13 August 2021
Contact Person: B Koop

Lachlan Shire Council
58-64 Molong Street
PO Box 216
CONDOBOLIN NSW 2877
P: 02 6895 1900
F: 02 6895 3478
E: council@lachlan.nsw.gov.au
ABN 82 815 250 829

Application Number: SSI-15548591Mod-1
Applicant: East Australia Pipeline Pty Ltd
Description of Proposed Modification: Compressor Station

The key intersections which have been assessed for potential project related traffic impacts are identified in Figure 5.3.

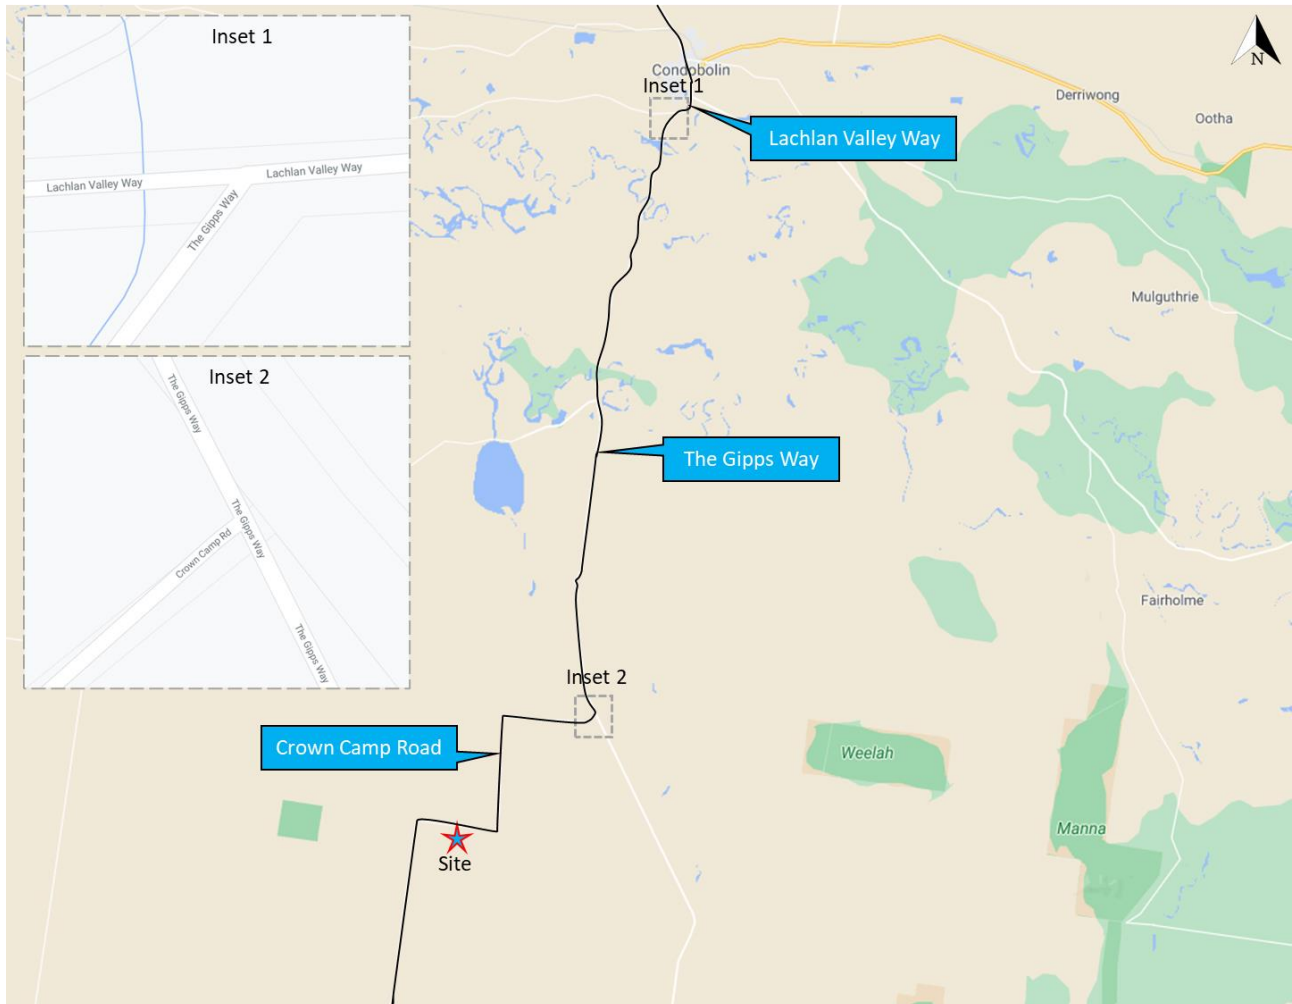
6. The Gipps Way – over the last 4 years, LSC has widened and strengthened the majority of The Gipps Way considered in this project. There are no concerns regarding the impact of this project on this road.
7. Intersection of The Gipps Way and Crown Camp Road – it is thought that the current arrangement is suitable and will cater for the additional vehicle movements.
8. Crown Camp Road - Table 5.6 contains errors. The existing seal is not 9m wide, rather it is 3.5m wide for the first 500m, with 3m gravel shoulders. This section of seal is in poor condition as per **Figure 1** below. It is likely that the additional 31 light and heavy vehicles will have a significant effect on the condition of this section of road. LSC request that the proponent reconstruct and seal this section of road to 9 metres prior to the on-site works.

9. Chainage 500 – 4000 of Crown Camp Road is an 8 metre wide gravel road which is in good condition, as per **Figure 2** below. The additional traffic on this road during construction will require additional maintenance grading. Typically LSC grade this route twice a year. The cost of this additional maintenance should be borne by the proponent during the construction period.

10. Chainage 4000 – 9500 of Crown Camp Road is an 8 metre wide gravel/natural surface road with limited gravel coverage. The current condition of this section of road is poor, as shown in **Figure 3** below. This is largely due to the above average rainfall received in the area in recent times.

The additional traffic on this road during construction will require additional gravel in order to ensure it can cater for the additional movements. The cost of gravel resheeting this 5km section of road should be borne by the proponent and be completed prior to construction works onsite. Typically LSC grade this route twice a year and additional maintenance grading will be required. The cost of this additional maintenance should be borne by the proponent during the construction period.

11. Both 90 degree corners within this section of road should be considered more closely in relation to vehicle movements. One of the 90 degree corners is shown in **Figure 4** below.

12. Chainage 9500 – 1100 of Crown Camp Road is an 8metre wide gravel road in good condition, as illustrated in **Figure 5** below. The additional traffic on this road during construction will require additional maintenance grading. Typically LSC grade this route twice a year. The cost of this additional maintenance should be borne by the proponent during the construction period.

13. Construction Site entry and exit is currently non-existent. Improvements should be considered for the entry/exit to the site compound. This should include consideration of long vehicle freight access, drainage, site distances, fence/gate setbacks in accordance with **Figure 6** below.
